# Rezoning Transportation Analysis

Petition Number: 2023-028

**From:** Jake Carpenter, PE

**Reviewer:** Travis Miller

SHEET NUMBER
RZ-1

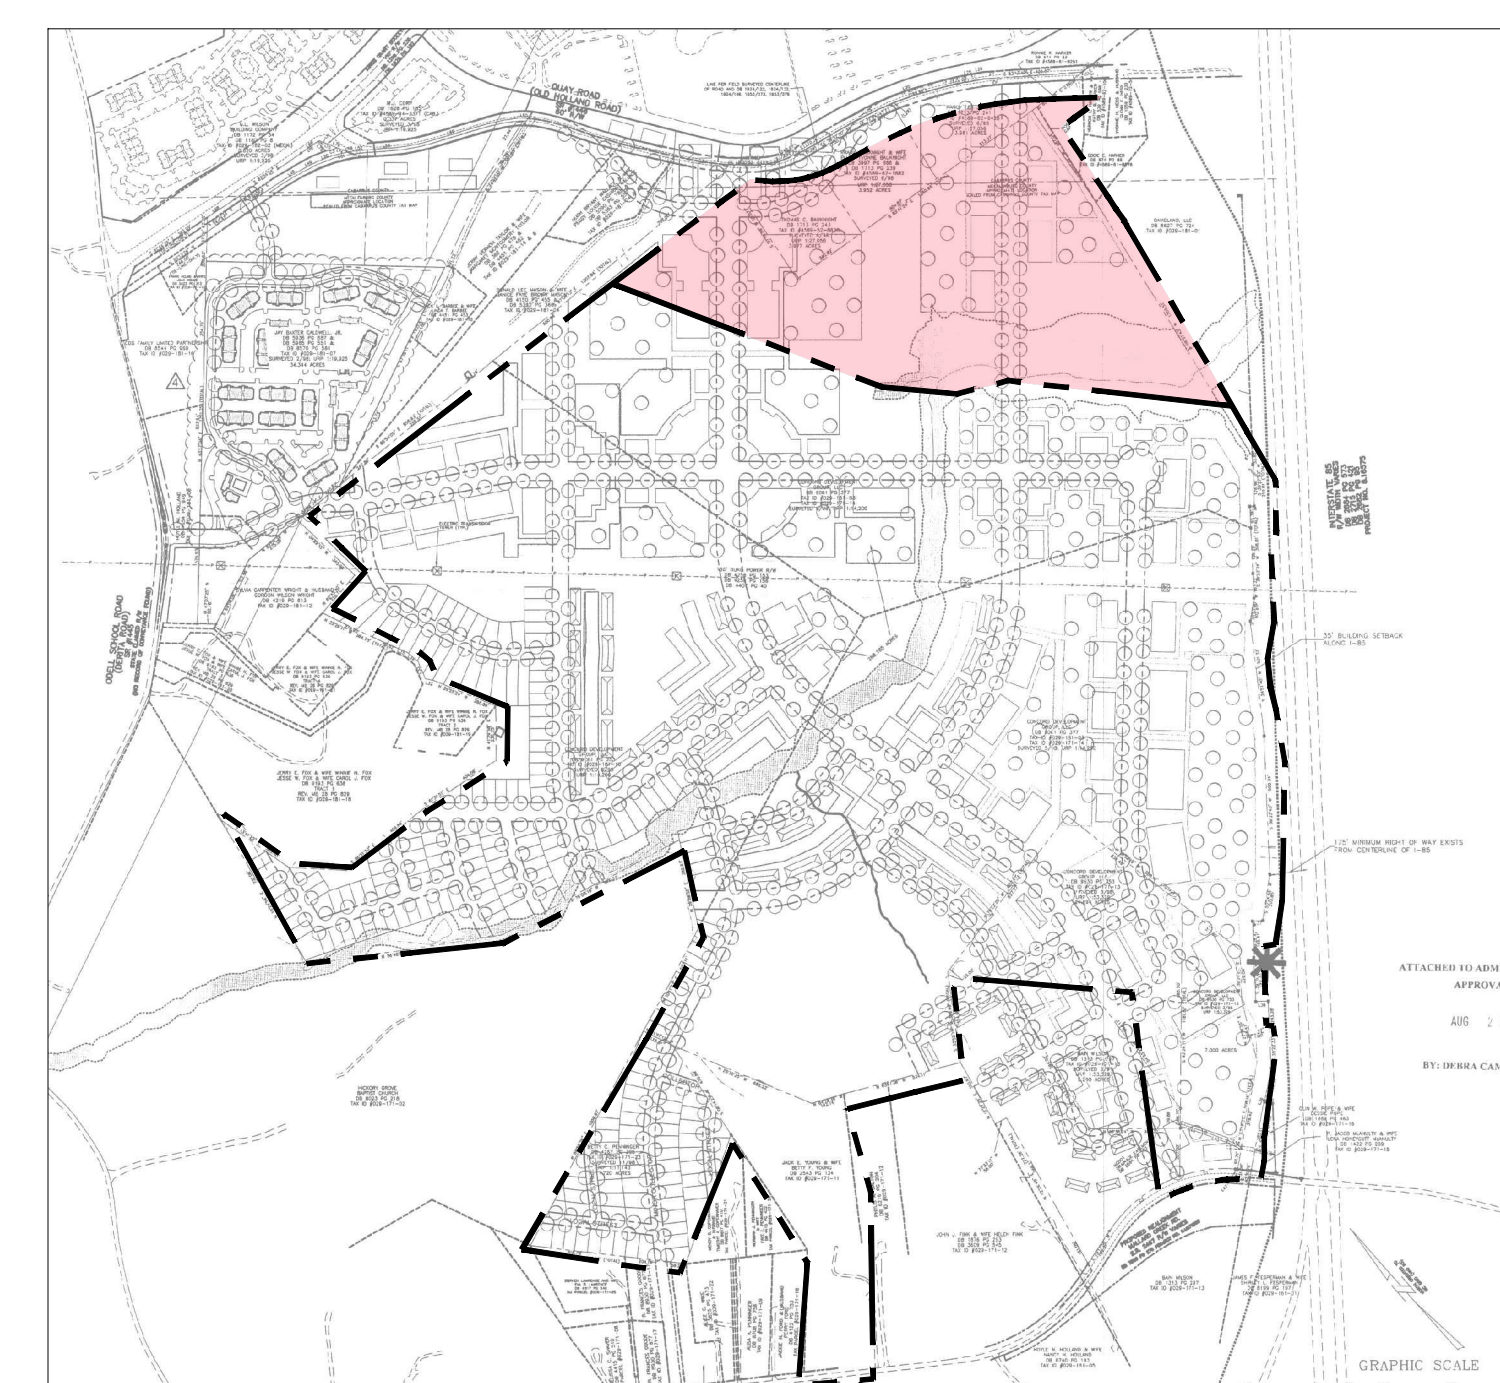
- ~~2. Revise site plan and conditional note(s) to commit to construct an 8-foot planting strip, and 8-foot sidewalk on newly N-S public Road per Chapter 20.~~

**Clarifying comment 9.20.2023:** ~~Label and call out 8-foot planting strip and 8-foot sidewalk on roads on site plan.~~

~~Outstanding comment from 9.20.2023: Based on latest conversation with Land Development Subdivision, please label Road B as publicly maintained within Mecklenburg county on site plan and alter conditional notes in sections 3, 4, and 5 to reflect changes.~~

5. Revise site plan and conditional notes(s) to commit to coordinating with CATS to provide a public connection to the nearest CATS bus stop to the North of the site.

**Clarifying comment 9.20.2023:** Edit conditional note to include coordination with CATS also.
